From: Peter Trebble [REDACTED]
Sent: 23 April 2018 09:51
To: Planning
Subject: M/35/18/HH – 36 The Layne, Elmer, Middleton on Sea. PO22 6JL

M/35/18/HH – 36 The Layne, Elmer, Middleton on Sea. PO22 6JL

We write in respect of the planning application to demolish the existing side single storey extension & erection of a side two storey extension plus dormer projection at 36 The Layne, Elmer.

sheet 1 of 3

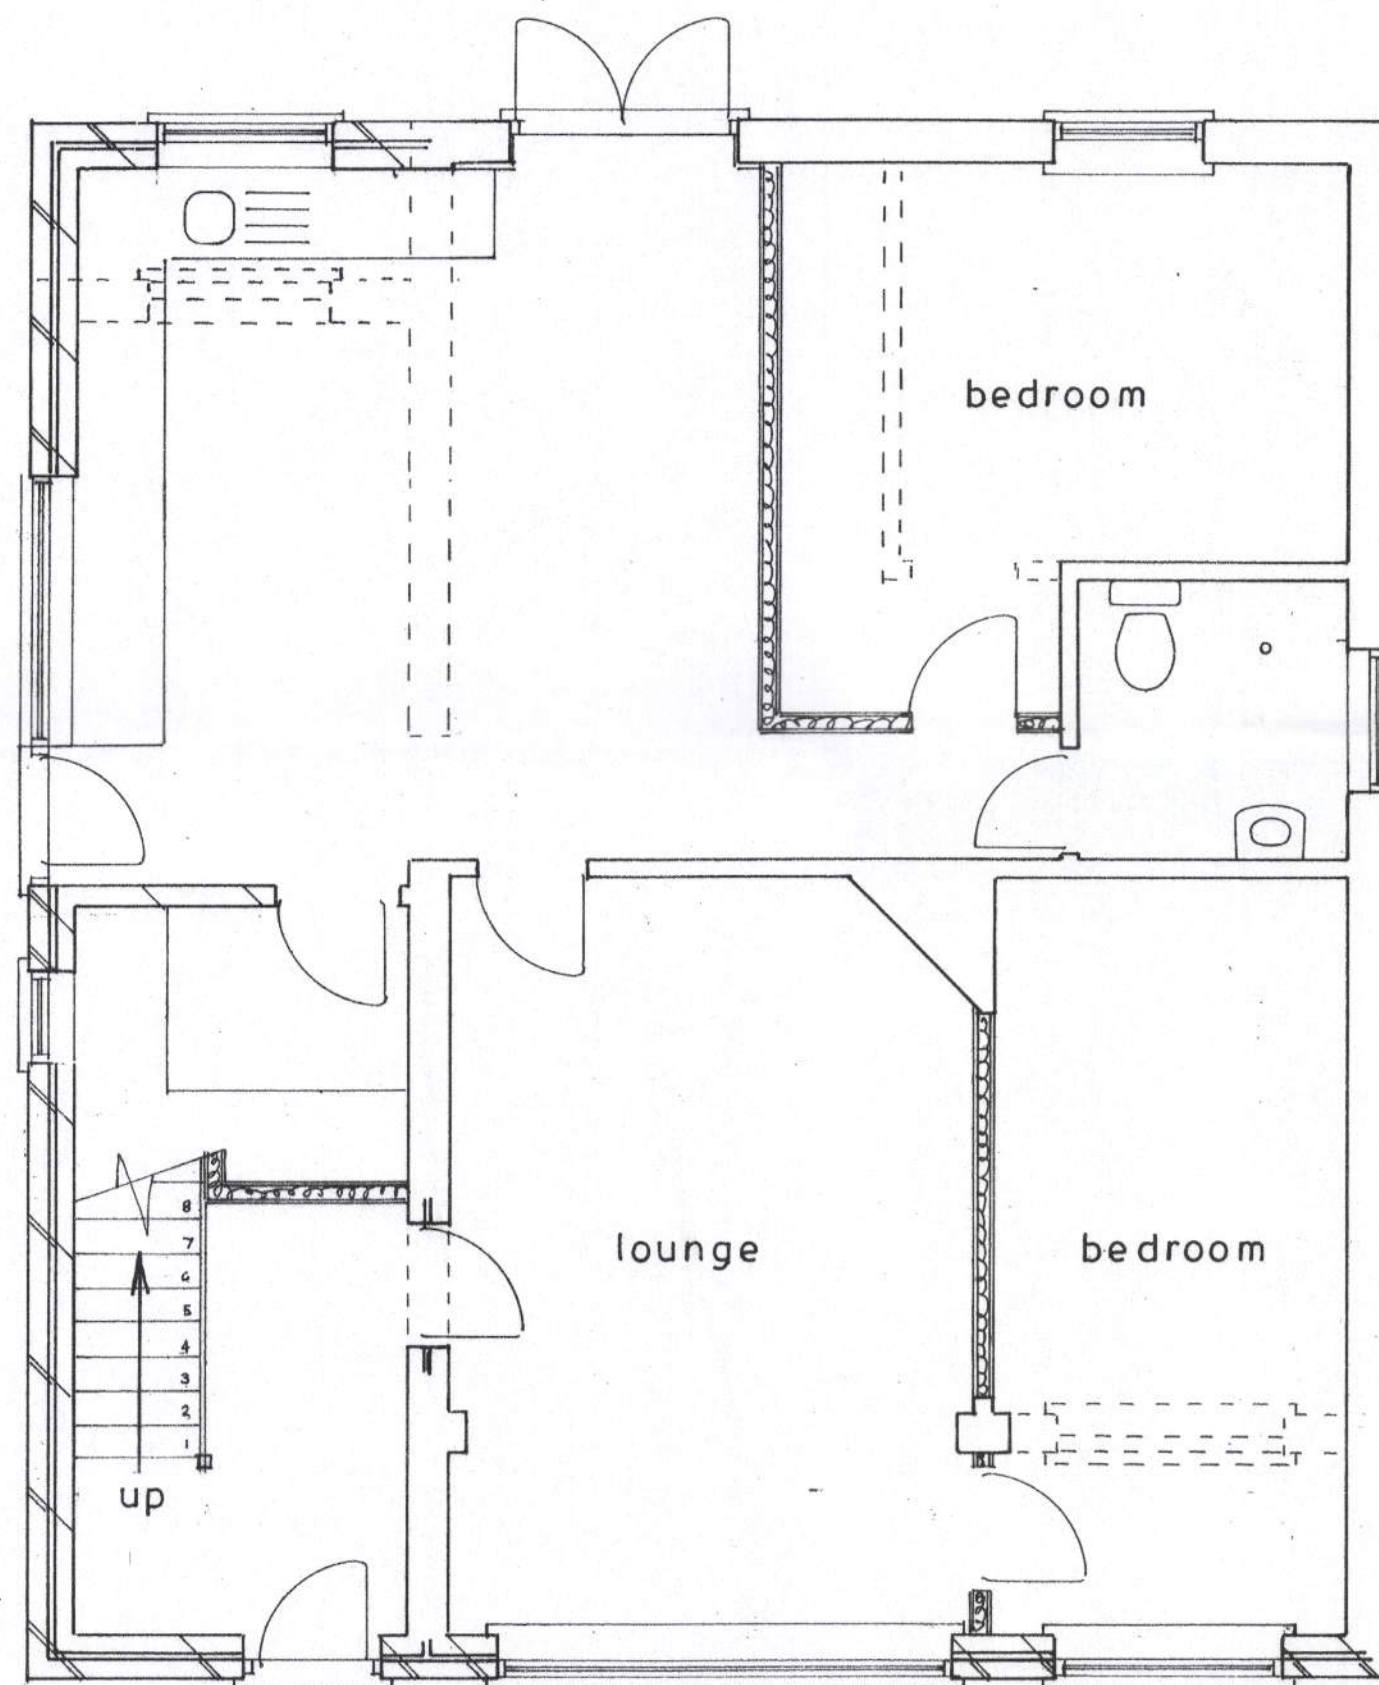
3. The proposal removes a garage from the property and replaces it with accommodation, this reduces the vehicle parking available. All parking must be contained within the property boundary as parking is not permitted on the road or verge fronting the property. An increase to four bedrooms has the potential of increasing the parking requirement and so it would be useful to know how the frontage of the property is to be developed, and

materials used to provide parking, as with limited surface water drainage in the area allowing water to permeate is an important factor.

south

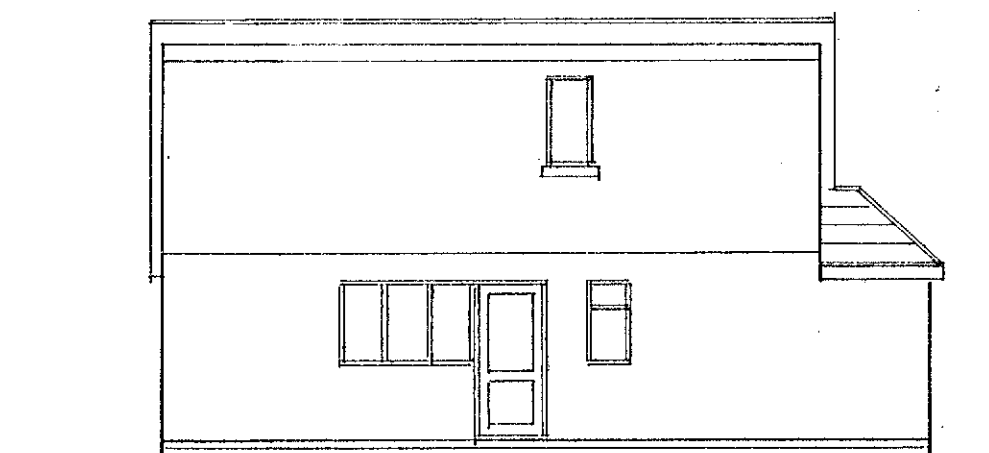
1. The first floor window on the southern elevation faces the window to our first floor shower room. It is assumed that this window will be non opening and will have obscure glazing.

1st floor plan
1 : 50

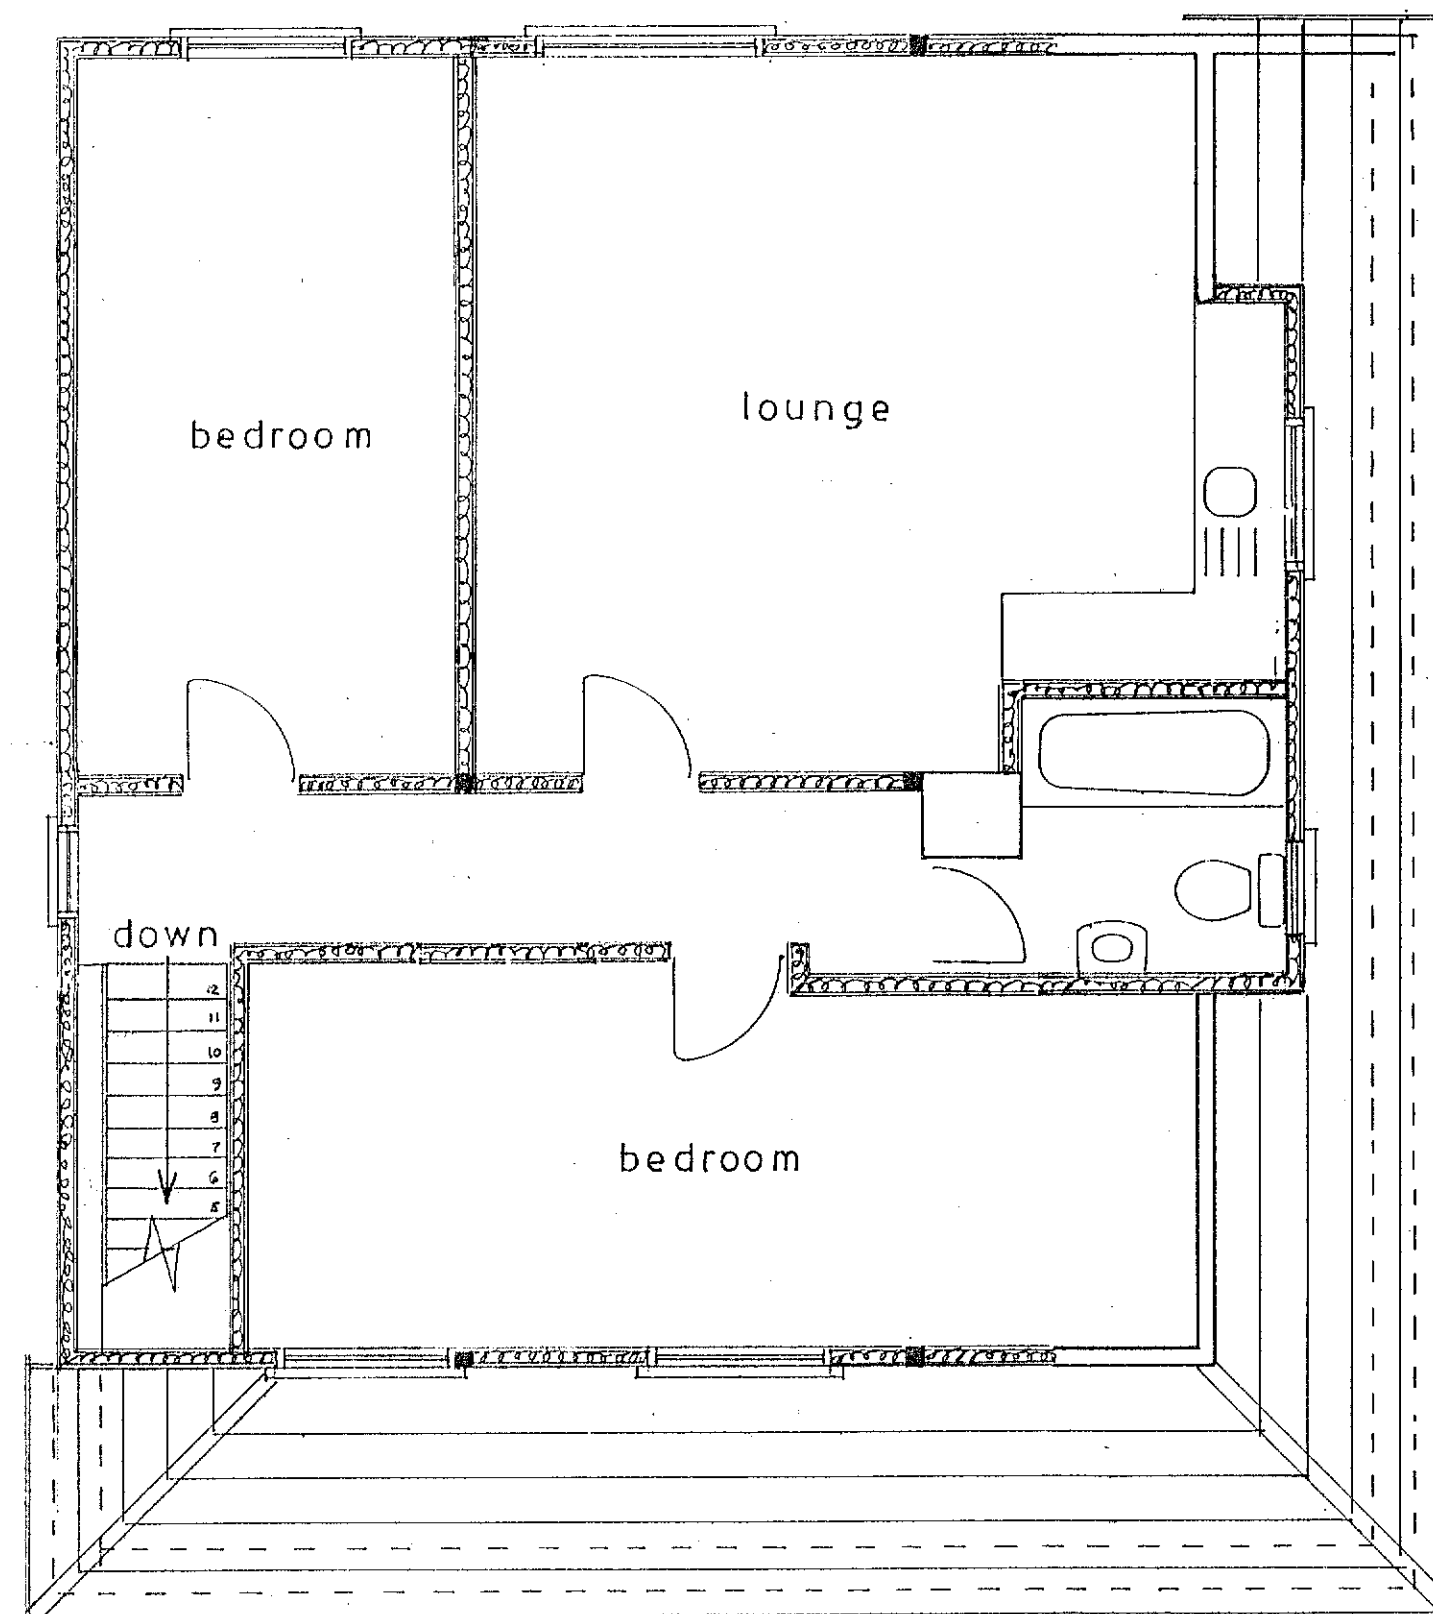
2. Whilst the application makes no mention of dividing the accommodation into flats, the plans show a kitchen area, lounge and two bedrooms on both the ground and first floor suggesting a change to separate ground and first floor flats. The deeds to properties on this estate contain a restrictive covenant saying "Not more than one dwellinghouse with garage or other outbuildings shall be erected on the land" so a conversion to two flats would not be in keeping with this covenant or other properties in the locality. Grateful to receive confirmation that the property will remain as one dwellinghouse.
